KIRKLEES METROPOLITAN COUNCIL INVESTMENT & REGENERATION SERVICE

Reference No:	2026/70/92150/E
Site Address:	Healey, 1, Penistone Road, Shelley, Huddersfield, HD8 8JN
Description:	Variation of condition 2 (plans) on previous permission 2025/92972 for erection of single and two storey extensions, internal and external alterations
Recommending Officer:	Ellen Gilbert

DECISION – Variation of Condition - Approved

Project	Proposed single storey extensions Internal and external alterations at 1 Healey Farm, Thunder Bridge Huddersfield HD8 8UN	01924 360873	2/106	Scale
Drawing	Proposed plans & elevations	Date 13/06/2025	R A	1:100
		Dwg No	4

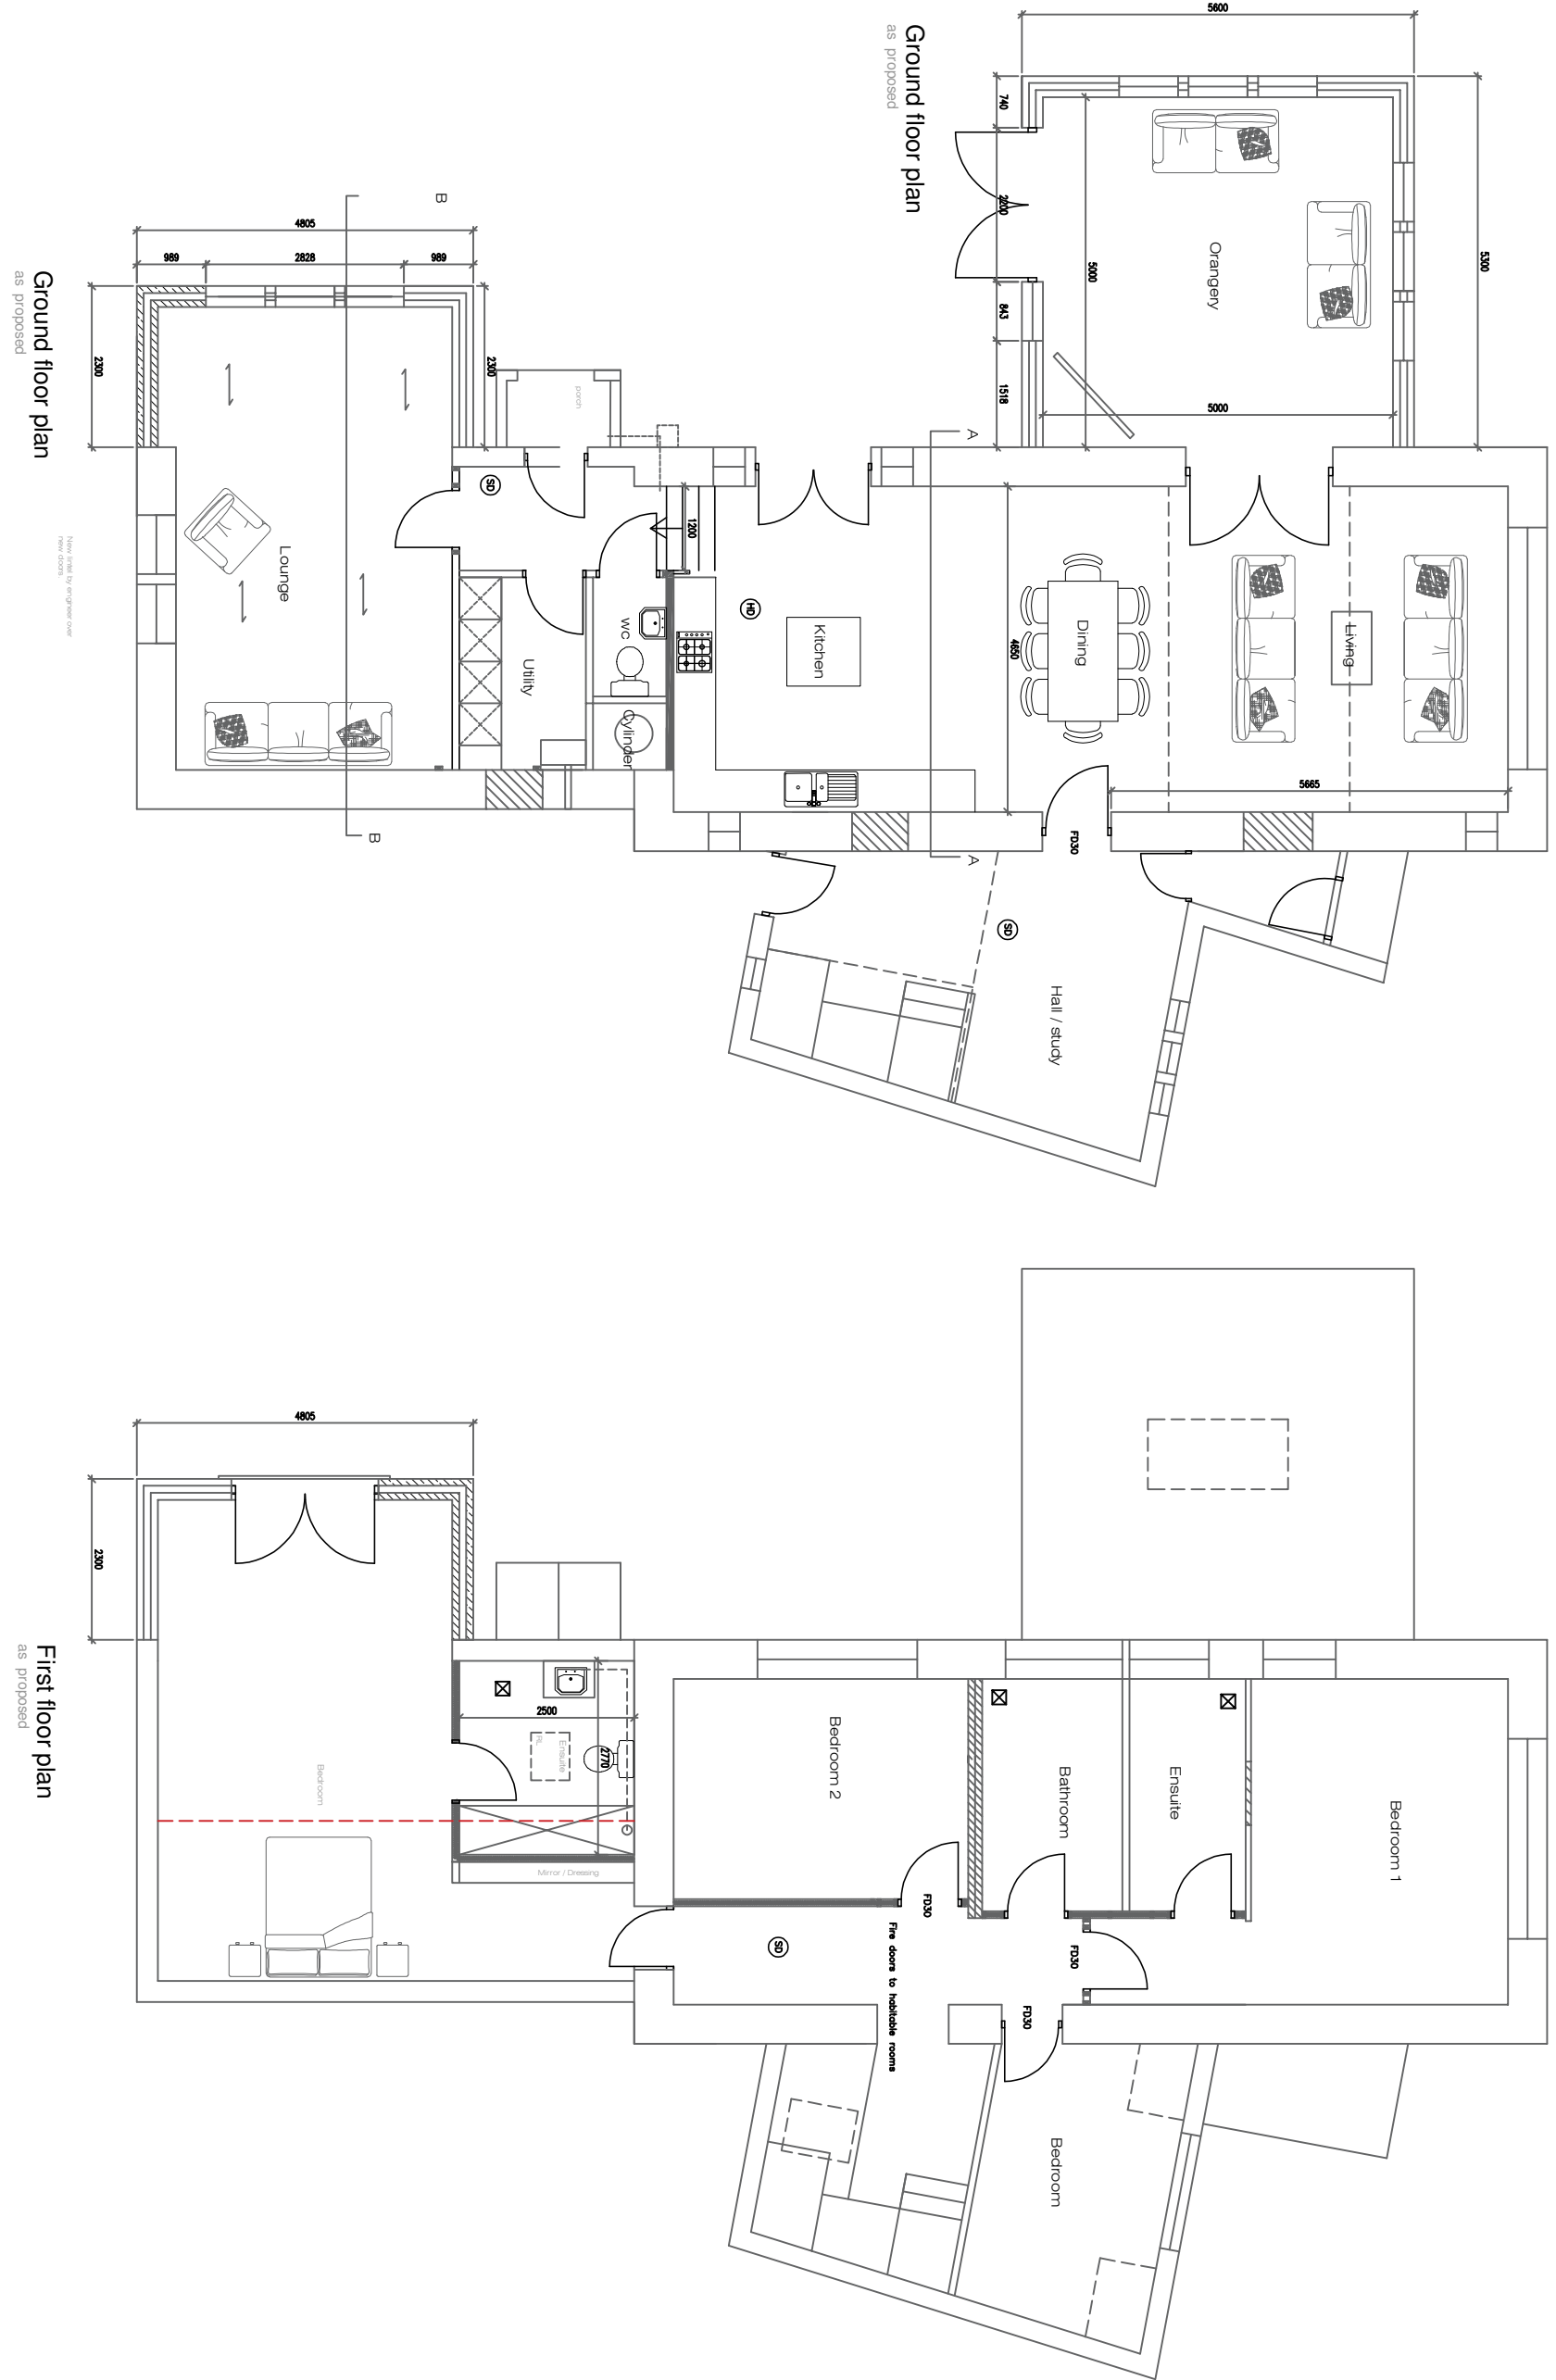
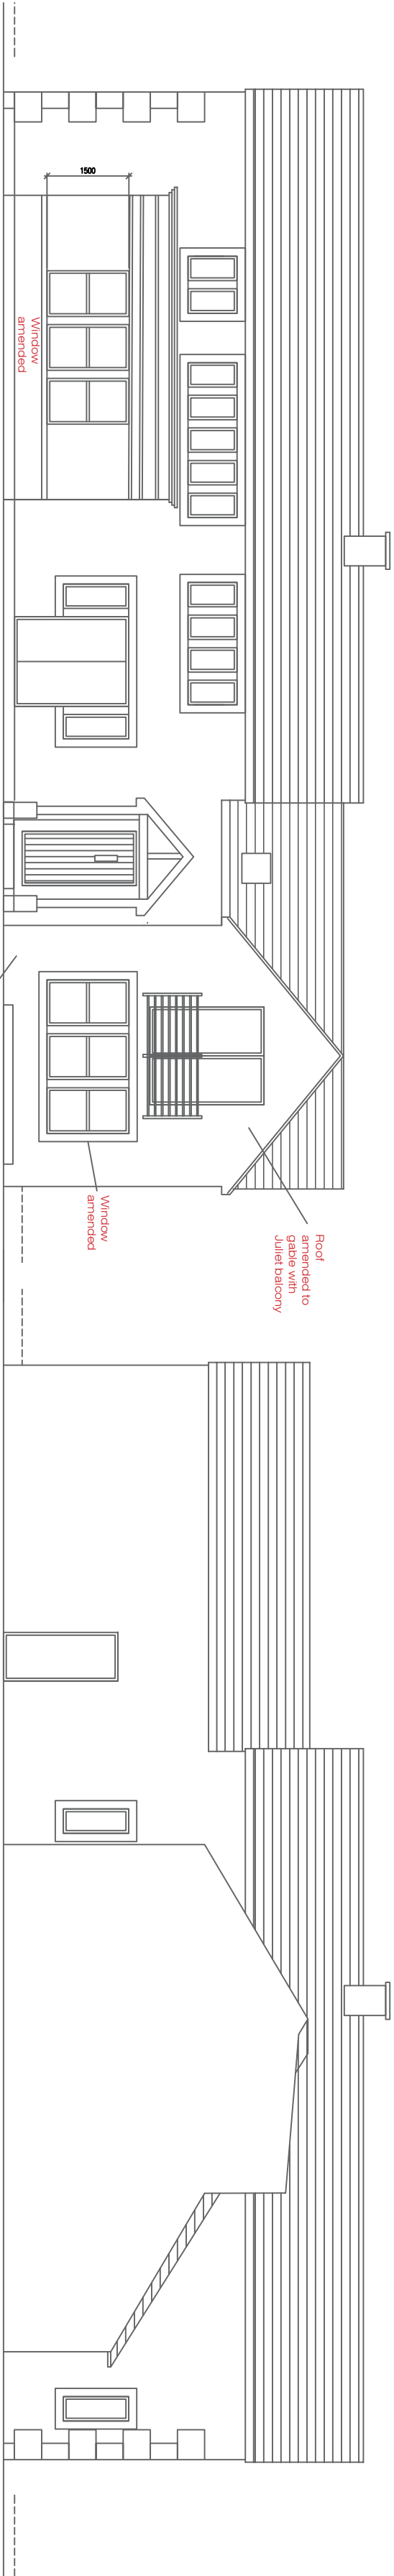
The purpose of the application is to amend the approved design of the windows, widen the two-storey extension by 1 meter and amend the roof from a lean-to form to a gable.

To the side elevation of the property, the ground floor window on the two-storey extension is to be redesigned to a 3-panel design, the roof form of the upper storey is to be gabled, and the upper floor is to feature a Juliet balcony.

To the ground floor of the property, the four paneled windows on the left of the side elevation and to the principal elevation are to be reduced to three panels and to the rear, a set of approved double doors is to be changed to a window

The proposal is not considered to lead to a material increase in overlooking over and above that which can take place already. The addition of a Juliette balcony to the side elevation is considered to be appropriate here and have less than significant impacts on neighbouring amenity, given the open aspect surrounding the property and the distance maintained between the surrounding dwellings. Having regard to the scale of the proposal and distance sited from neighbouring properties, along with the fact that no new openings are proposed in the re-submitted plans, the proposal is considered to accord with the aforementioned policies.

Having taken the above into account, the proposed amendments would not cause any significant harm to the visual amenity of either the host dwelling or the wider street scene, complying with Policy LP24 of the Kirklees Local Plan (a) in terms of the form, scale and layout and (c) as the approved extension would continue to form a subservient addition to the property. In addition, given the ample curtilage and oblique angle at which the property is situated, a terracing effect would be avoided, and it is considered that the widening of the extension by 1 meter is therefore proportionate.

Given the varying levels and gable design of the existing roofing of the host dwelling, the introduction of a gable roof form is deemed appropriate in this case.

The reduction in the size of the windows and the replacement of a proposed double door with a window is also considered acceptable in this case, as no new openings are proposed and the plans show a paneled fenestration design in keeping with the character of the property and the surrounding area.
